## Online Comment

**Application** H13-0292-25  
**Location** Holly Tree House Fengate Moulton Chapel PE12 0XR  
**Proposal** Proposed replacement dwelling

**Name** Gregory Watkinson, Conservation Officer  
**Address** Conservation Officer

**Elevations as proposed**

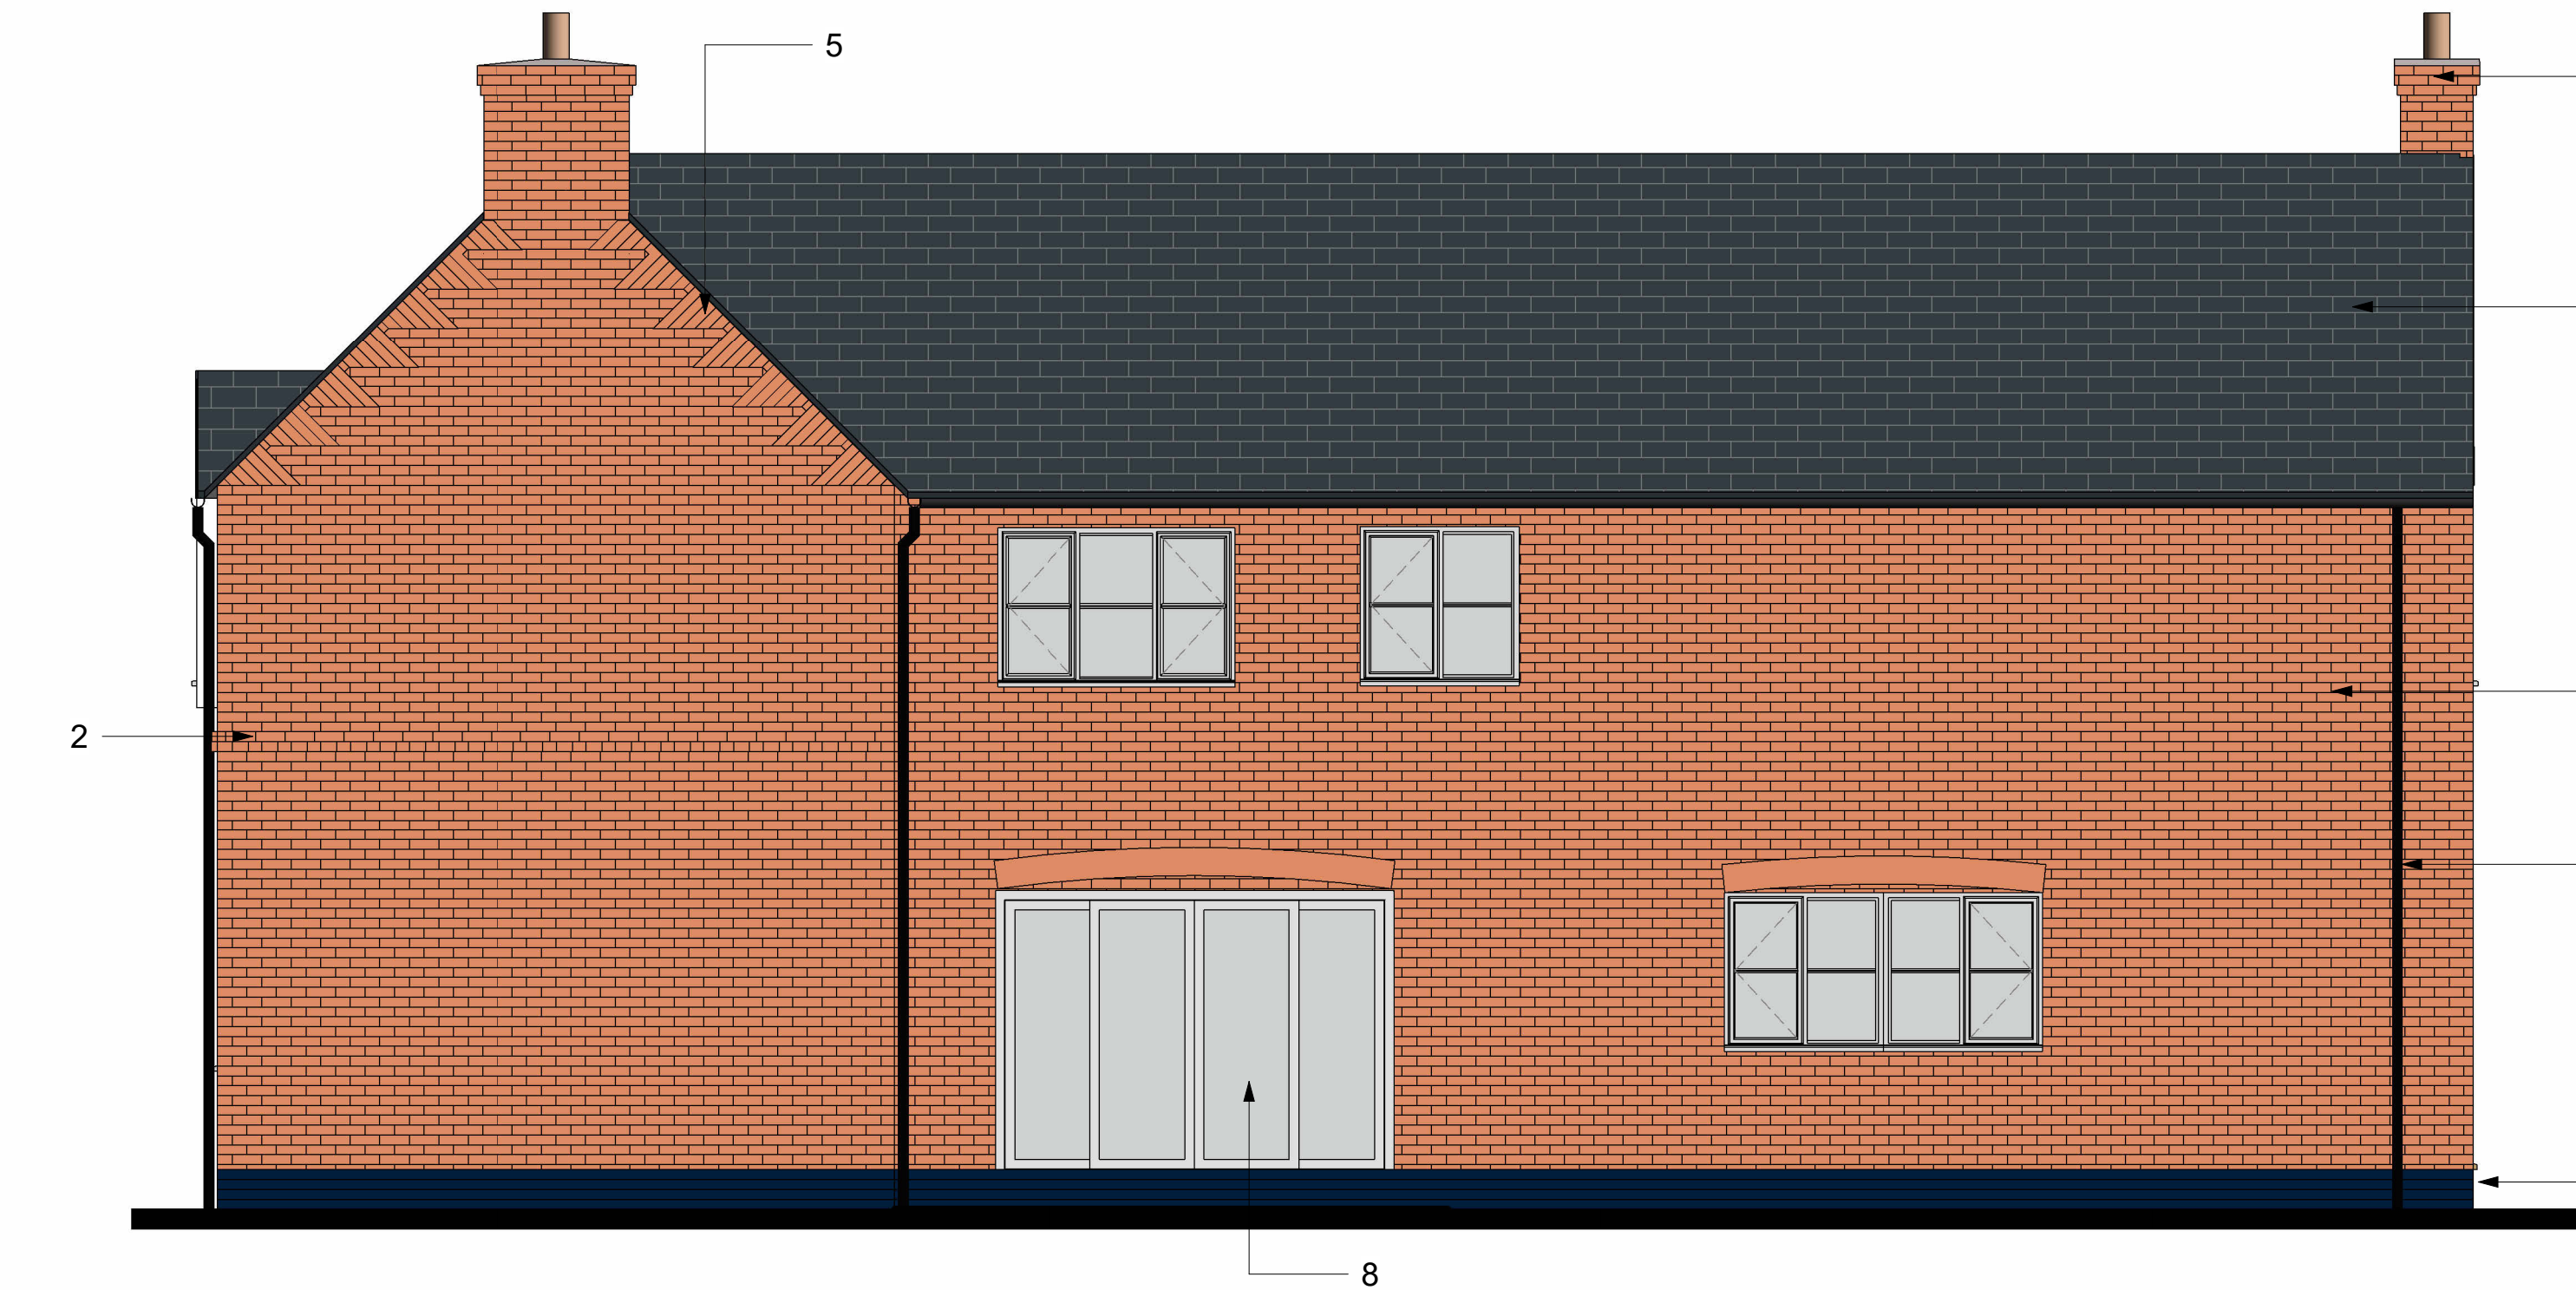
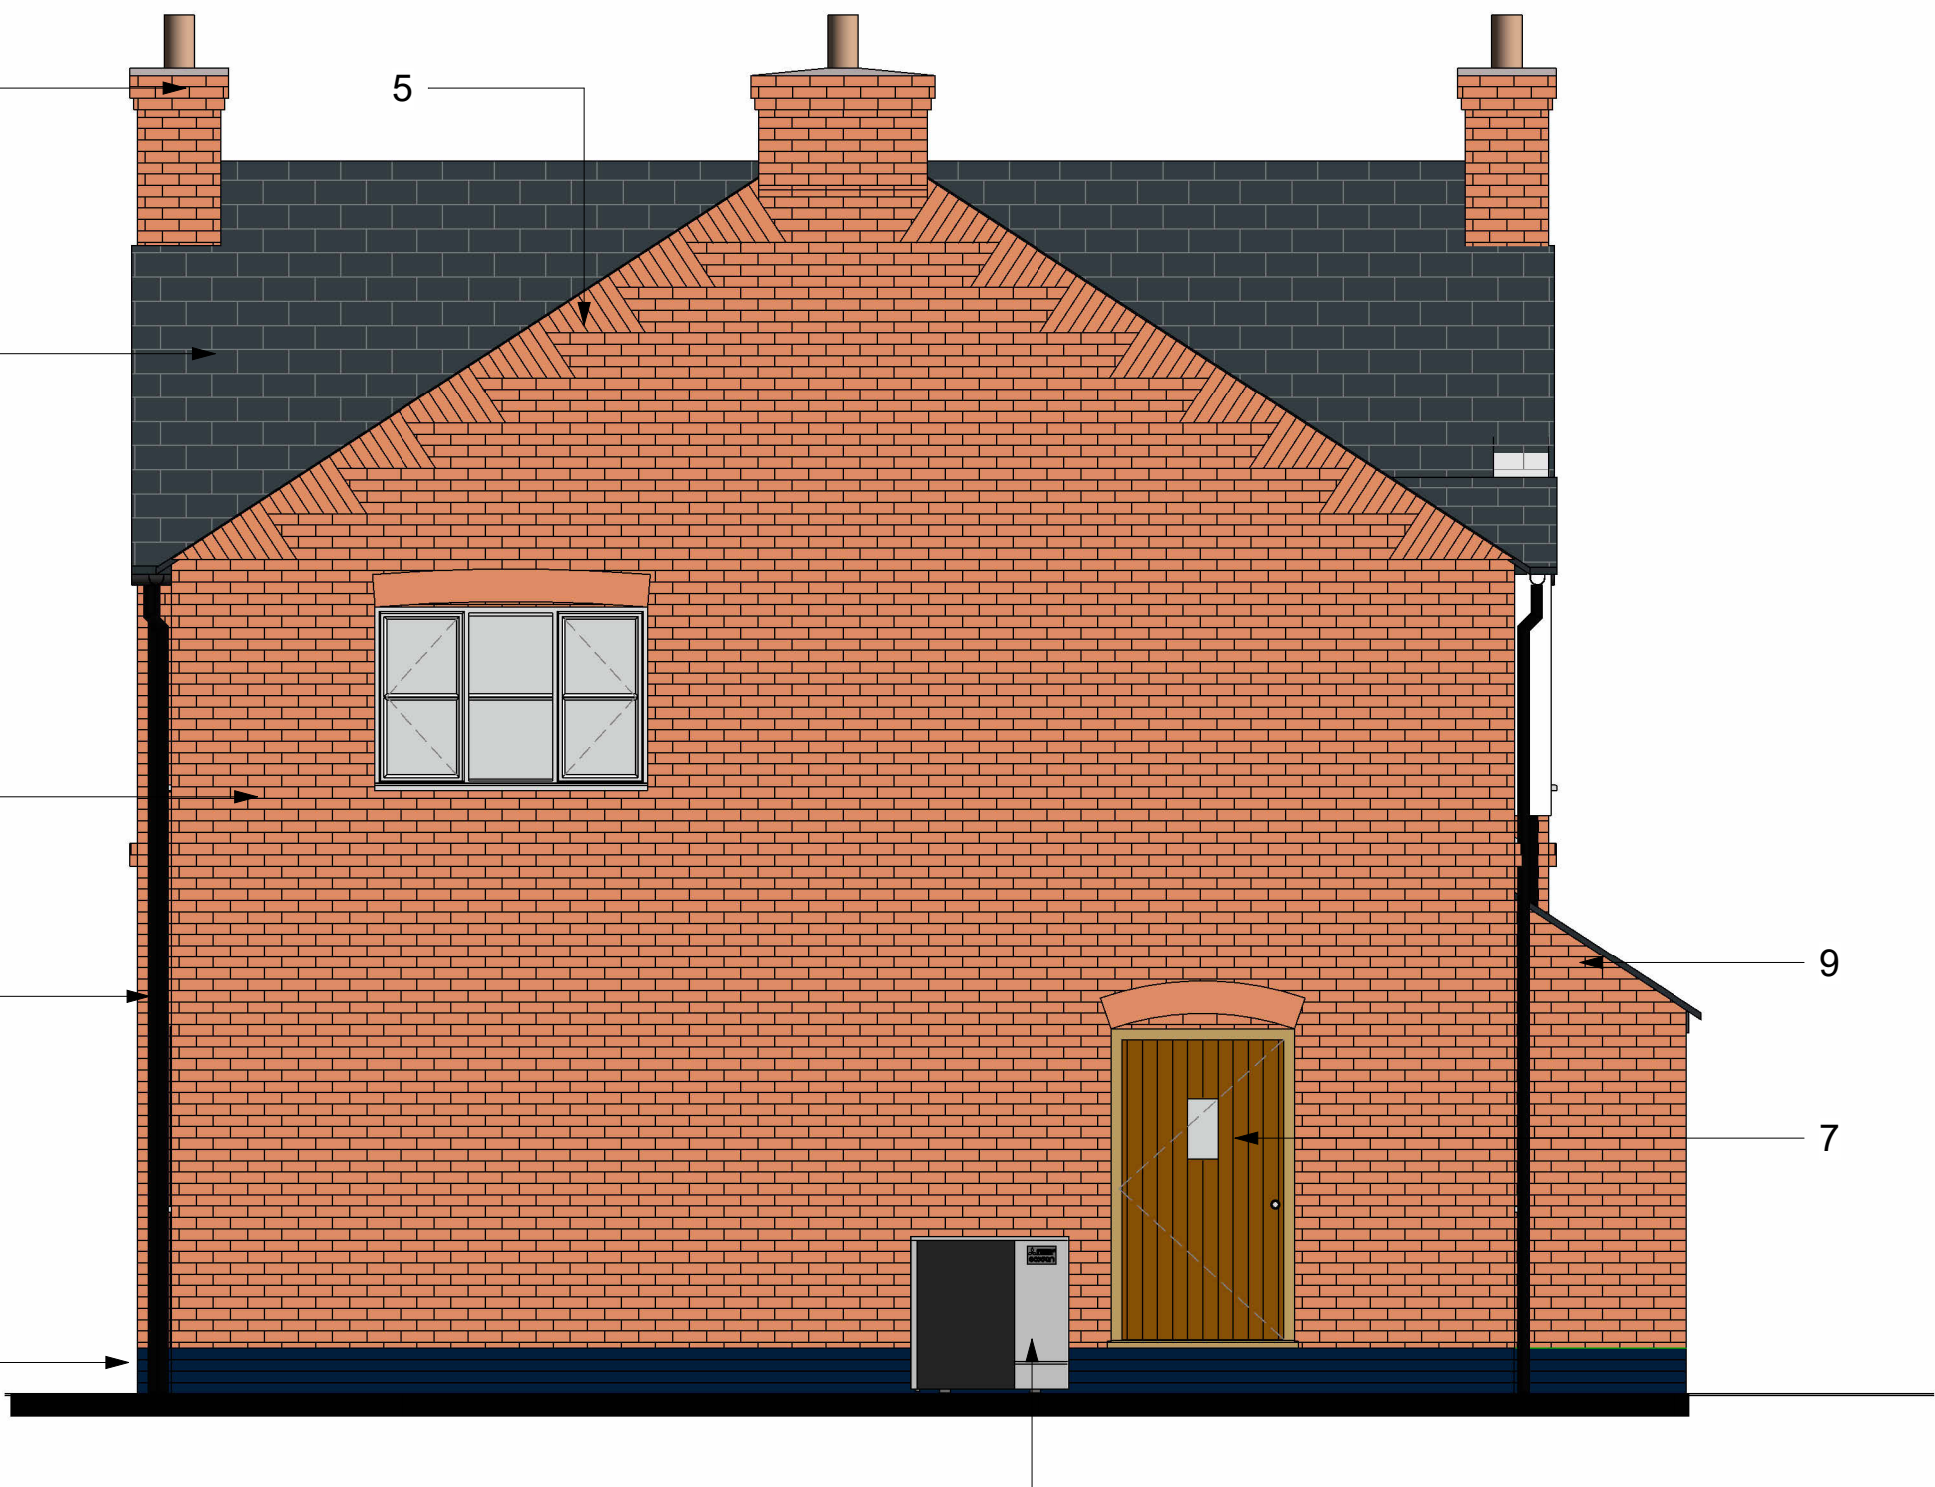
The design is of a relatively unremarkable nature, and it would have been preferable to see some more detail of the original property referenced in the final design, such as the mid-section crenellation. However, the design is of a nature that I do not feel that it would represent a material risk to the setting of the adjacent listed barn, either in scale or overall design.

I would, however, request that with an approval, the determination should be made conditional, pending details of external materials, windows, doors and rooflights for both the house and the car port.
